CITY OF ALBUQUERQUE

Re: Precision Eye Center
7521 Alameda Blvd. NE
Traffic Circulation Layout
Engineer's Stamp 04-20-23 (C19-D070)

Re: C19-D070 Responses to TCL Comments received on 4/20/2023

TRAFFIC
CIRCULATION
LAYOUT

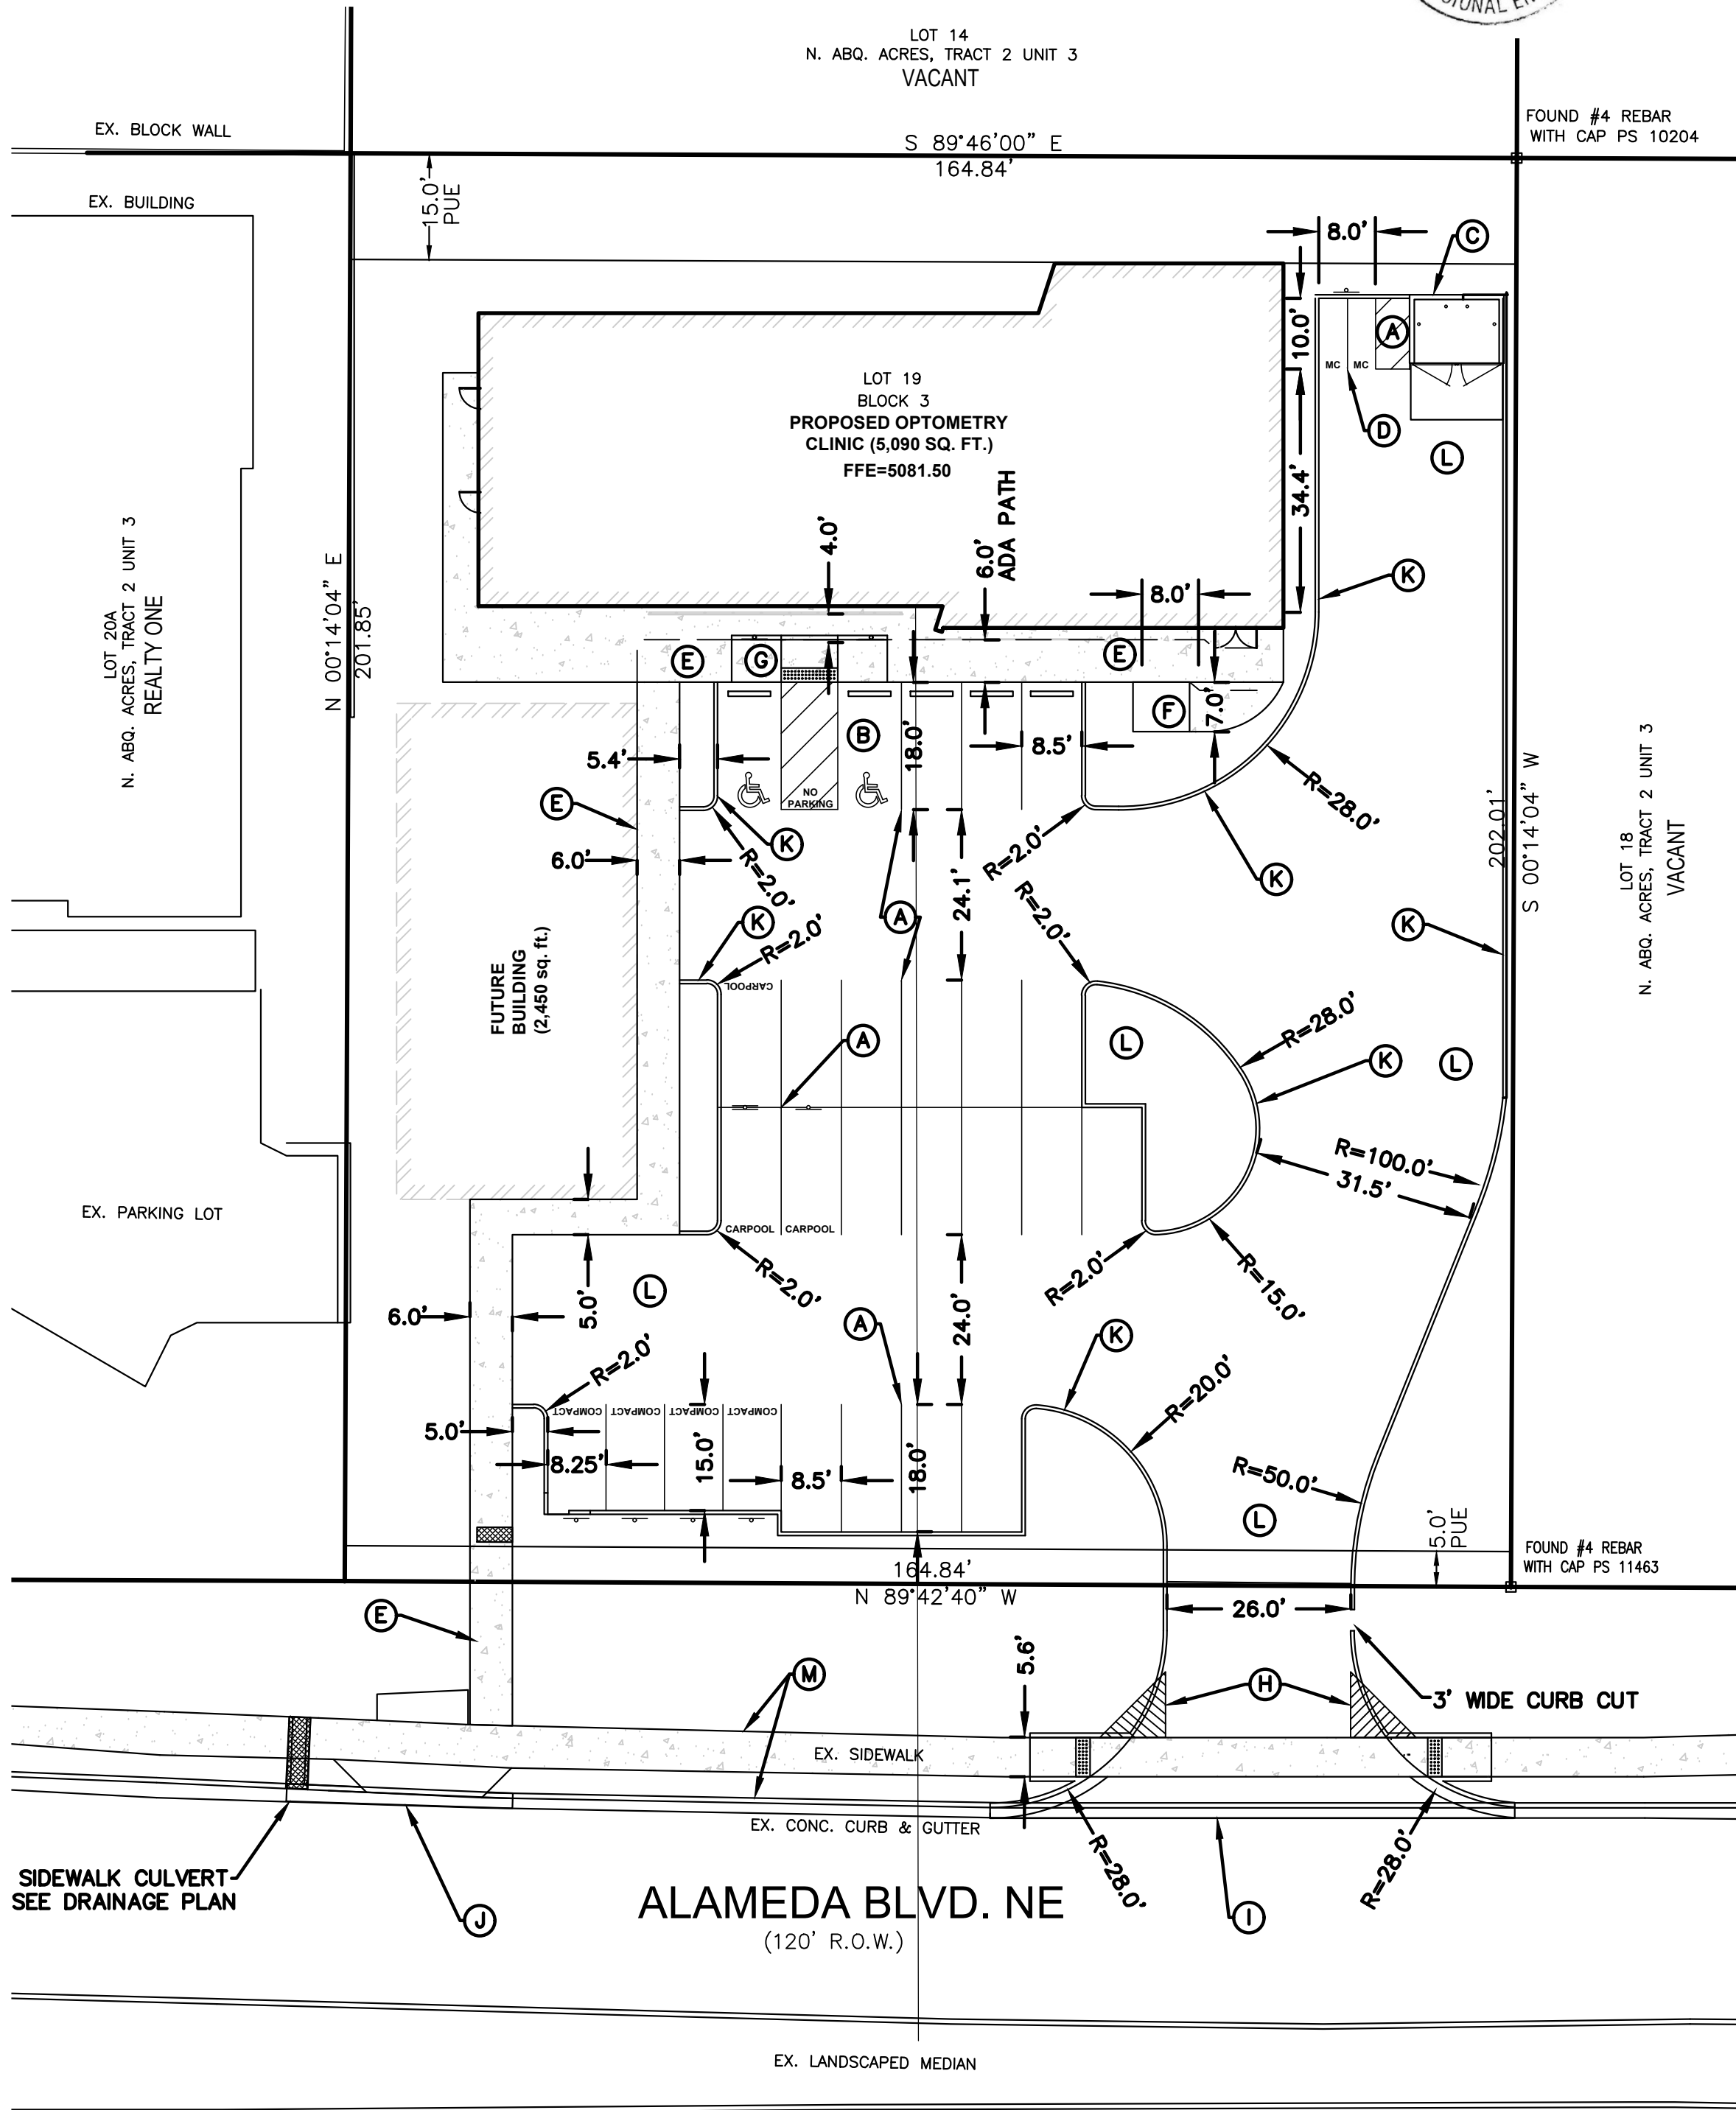
- Please show on the site plan the radius for the site access.
Radius dimension line added
- Provide 6 ft. wide ADA pathway from the public sidewalk to the building entrance.
6ft wide path now shown

- Please show on the site plan the 6 ft. wide ADA pathway from the ADA parking aisle to building entrance. Provide the width for the highlighted way (key note E).
6ft wide path now shown

- Add a note stating "All broken or cracked sidewalk must be replaced with sidewalk and curb & gutter." A build note must be provided referring to the appropriate City Standard drawing.
See keyed note "M"

SITE
DETAILS

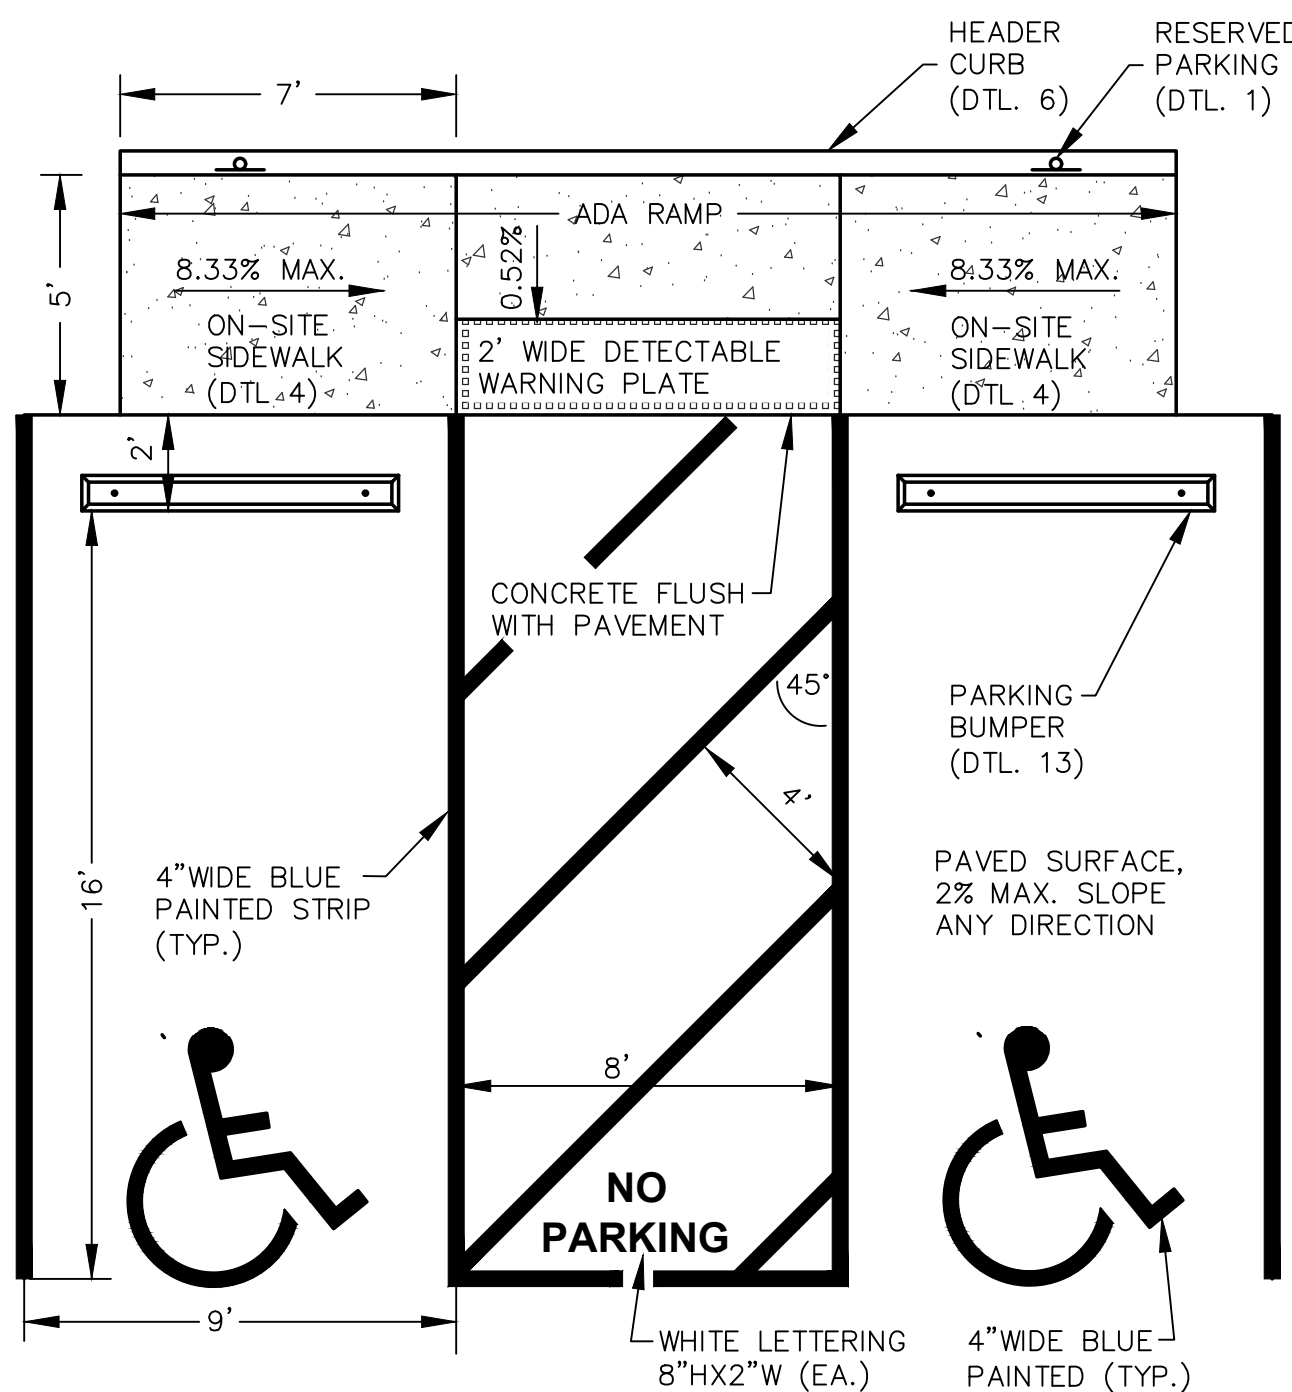
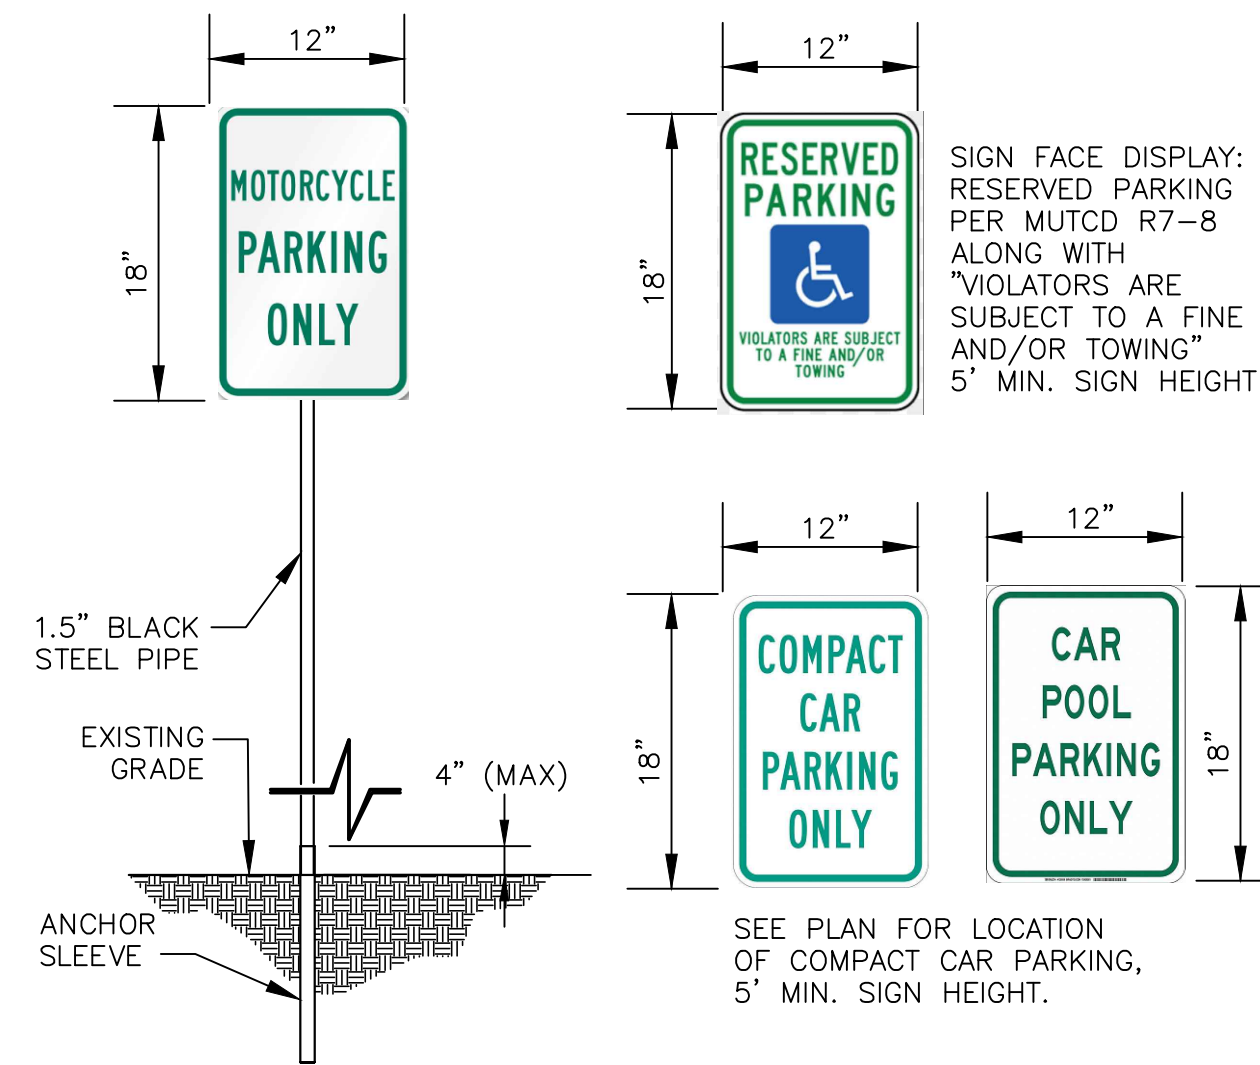
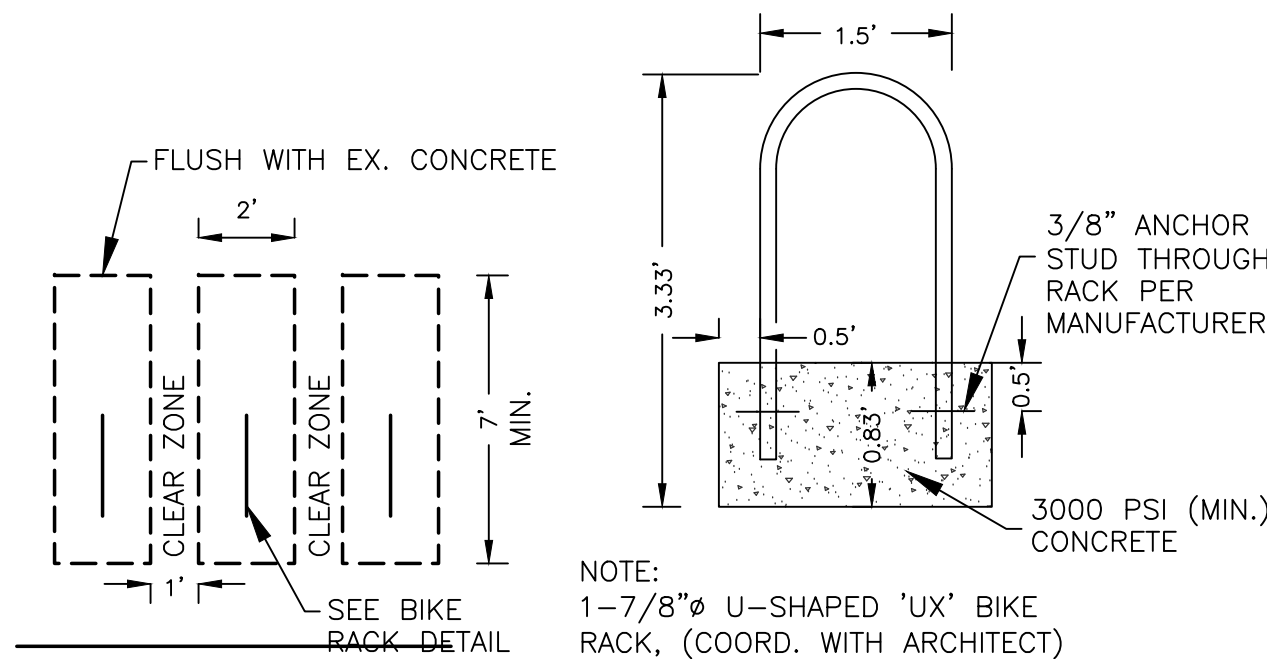
- Details sheet is missing.
Detail sheet added
- Please provide details for all the proposed signs and pavement marking.
Shown on detail sheet
- Provide Bike Rack details.
Shown on detail sheet
